From: Brenda Larsen
Sent: Tuesday, January 28, 2014 7:39 AM
To: Jeff Watson; Lindsey Ozbolt
Subject: RE: Kittitas County Notice of Application SP-13-00006 Willard Lot 2

Re: Willard Short Plat

Willard Lot 2 Short Plat SP-13-00006

WILLARD LOT 2 SHORT PLAT  
 PART OF SECTION 25, T. 18 N., R. 18 E., W.M.  
 KITTITAS COUNTY, WASHINGTON

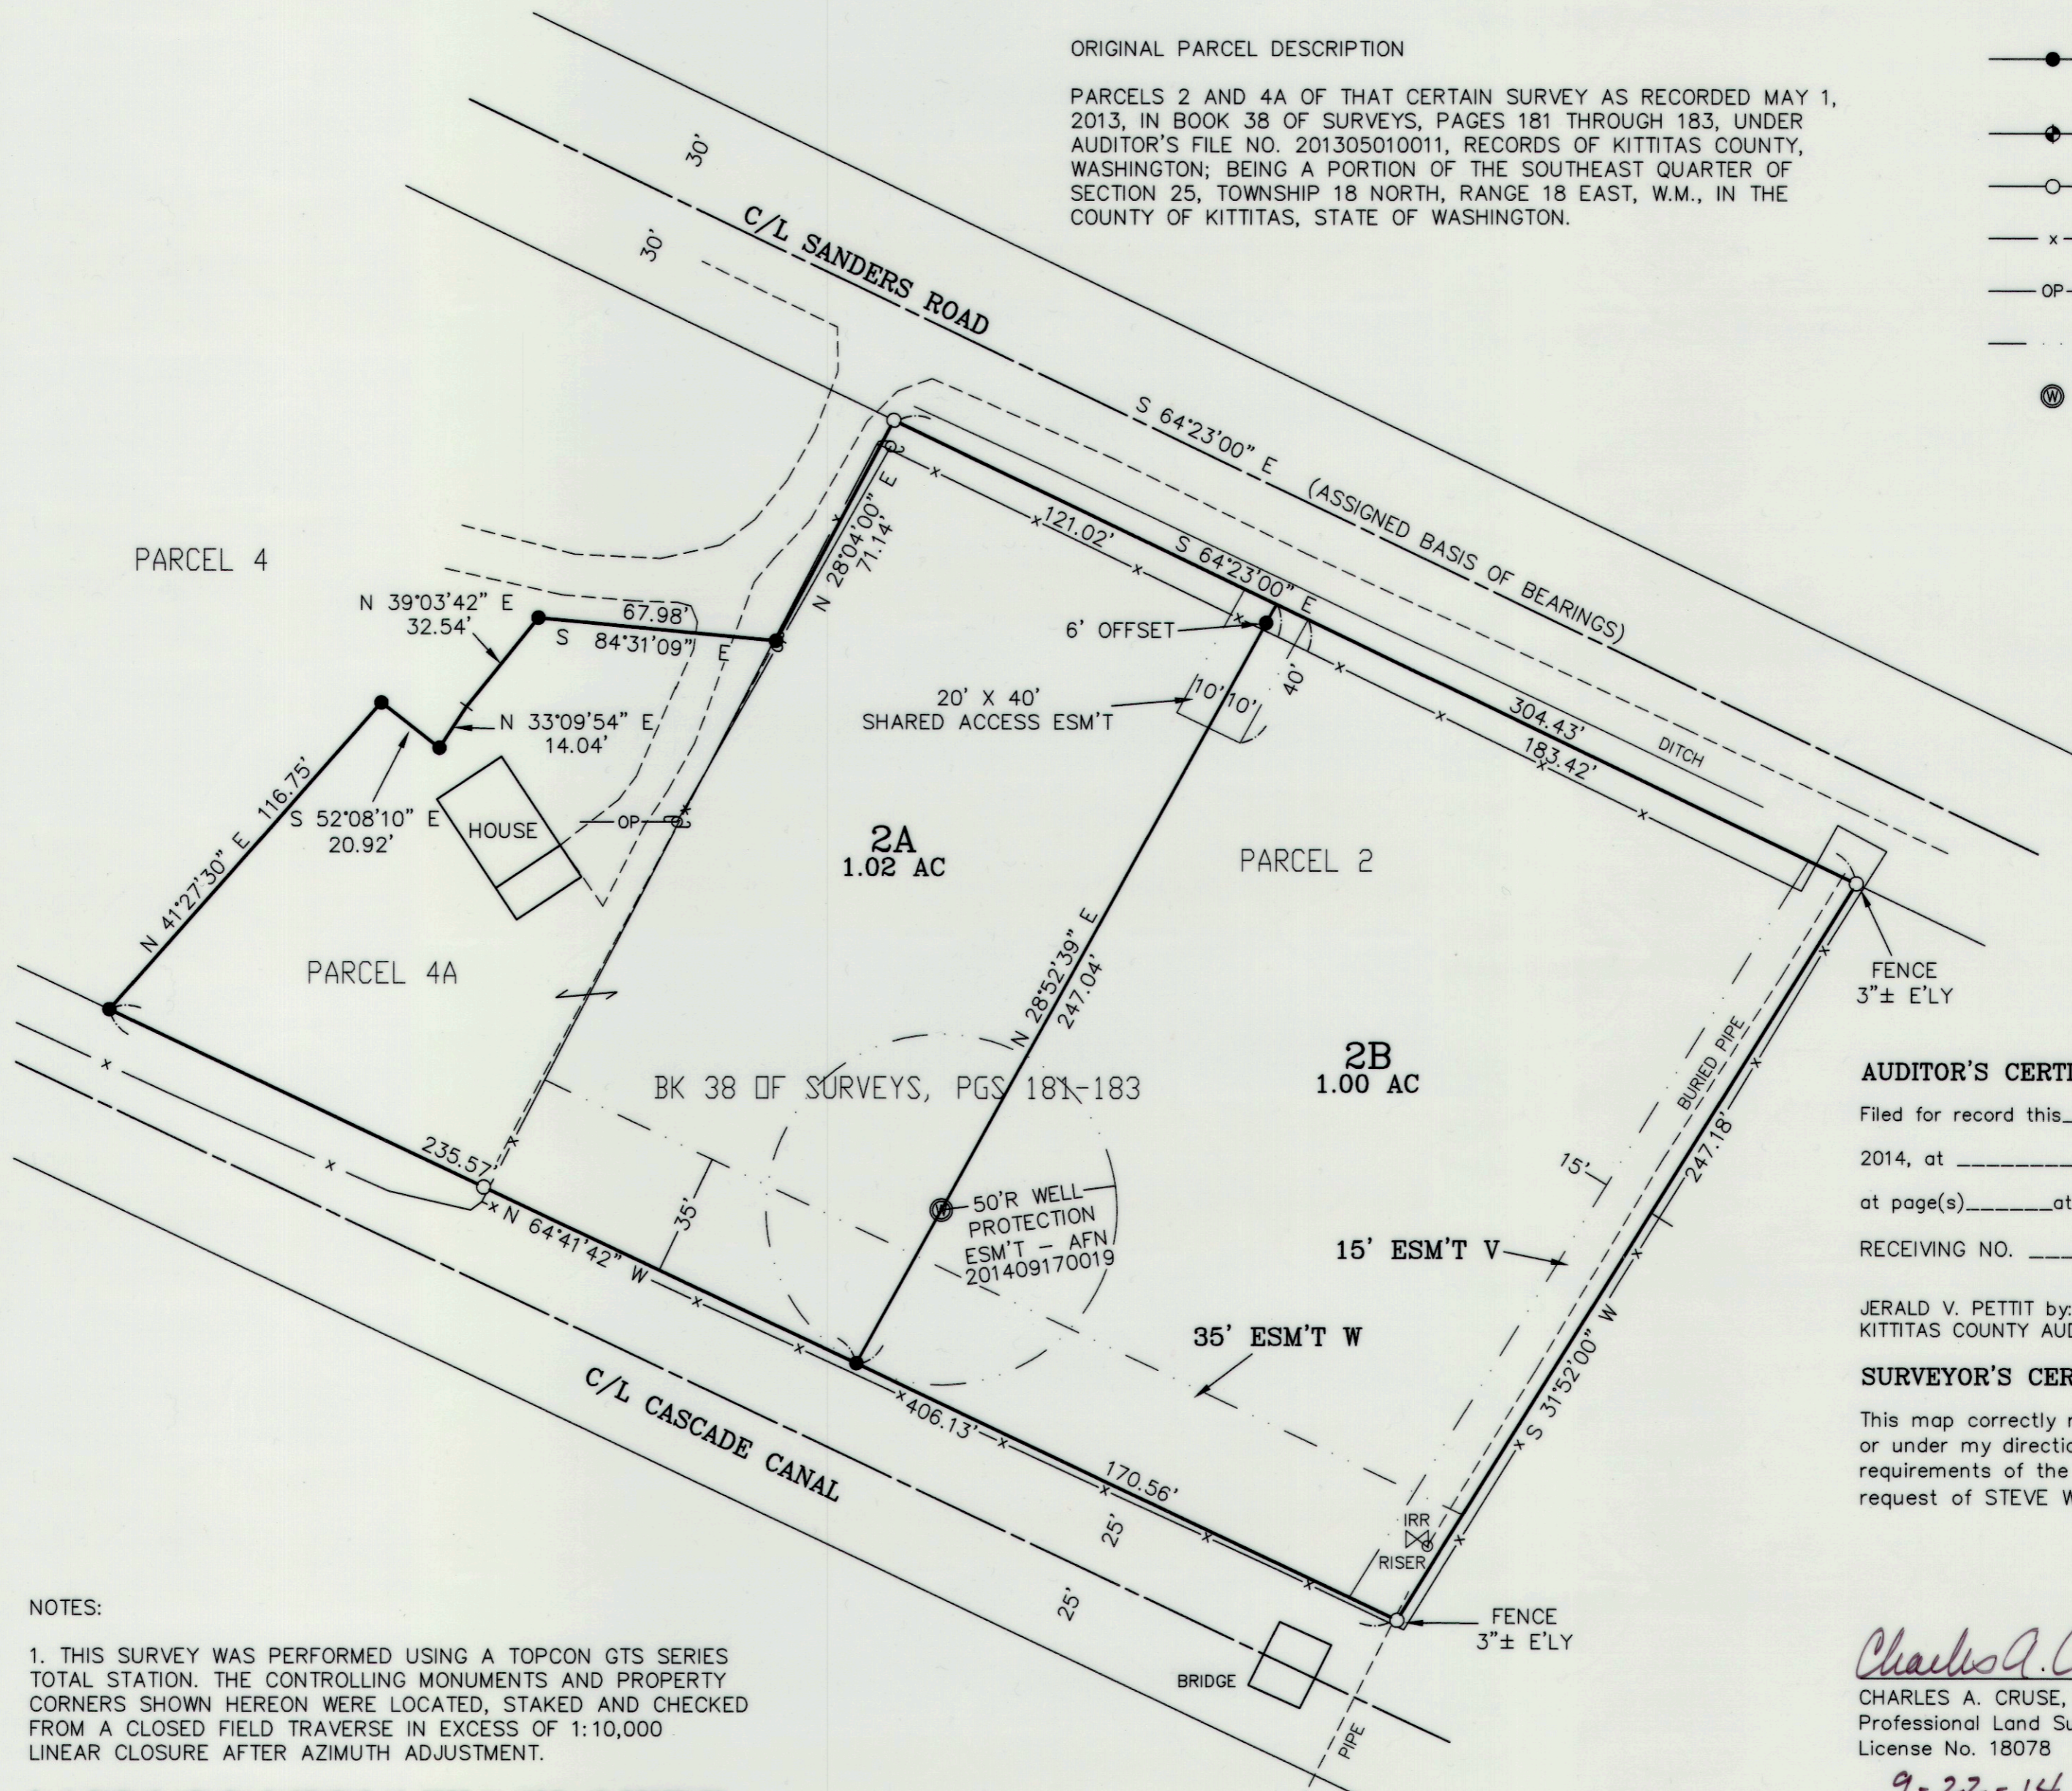
- This property has been designated as IR3 for Wildland Urban Interface Code requirements.
- The driveway(s) for the new property must comply with Kittitas County Code, i.e. any driveway greater in length than 150' shall be no less than 16 feet in width.
- The addresses shall be posted at the front of the property and easily visible to emergency responders.
- All future development must comply with the International Fire Code.
